Subject: planning application AL/23/20/HH

With respect to planning application AL/23/20/HH Innisfree 26 Belle Meade Close I would like to register an OBJECTION to the submitted application.

Proposed Front Elevation

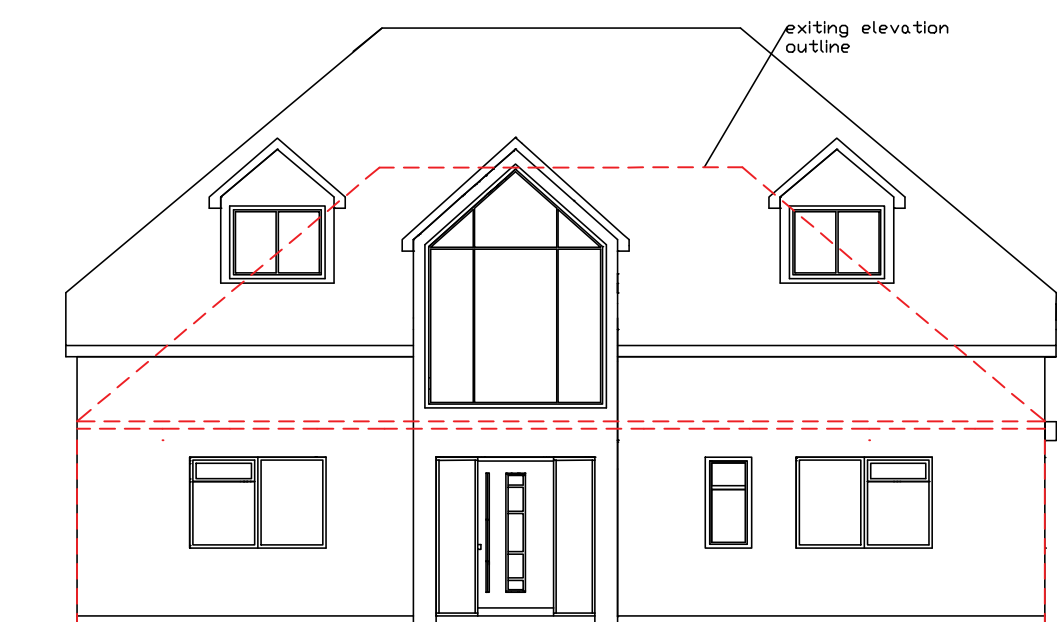
The Plans as submitted primarily change the property at 26 Belle Meade Close from a Bungalow (with mitigating fencing to protect our privacy) to a large two story house with significant views over our property impinging upon our internal privacy (primarily bedroom areas) and enjoyment of our gardens. The plans as submitted have a fair amount of artistic licence showing foliage and distorting the closeness of the property to our boundary and the significant impact the conversion to a house will have to our right to privacy from being overlooked if the plans are agreed as is. Given the proximity of the Bungalow to the boundary its existing roofline is significantly higher than that of Reed Cottage as the footings were built higher, which exacerbated the initial privacy concerns as the property, was looking down into our bedroom windows, the proposed changes to the roofline will dwarf our Bungalow and will make privacy almost impossible.
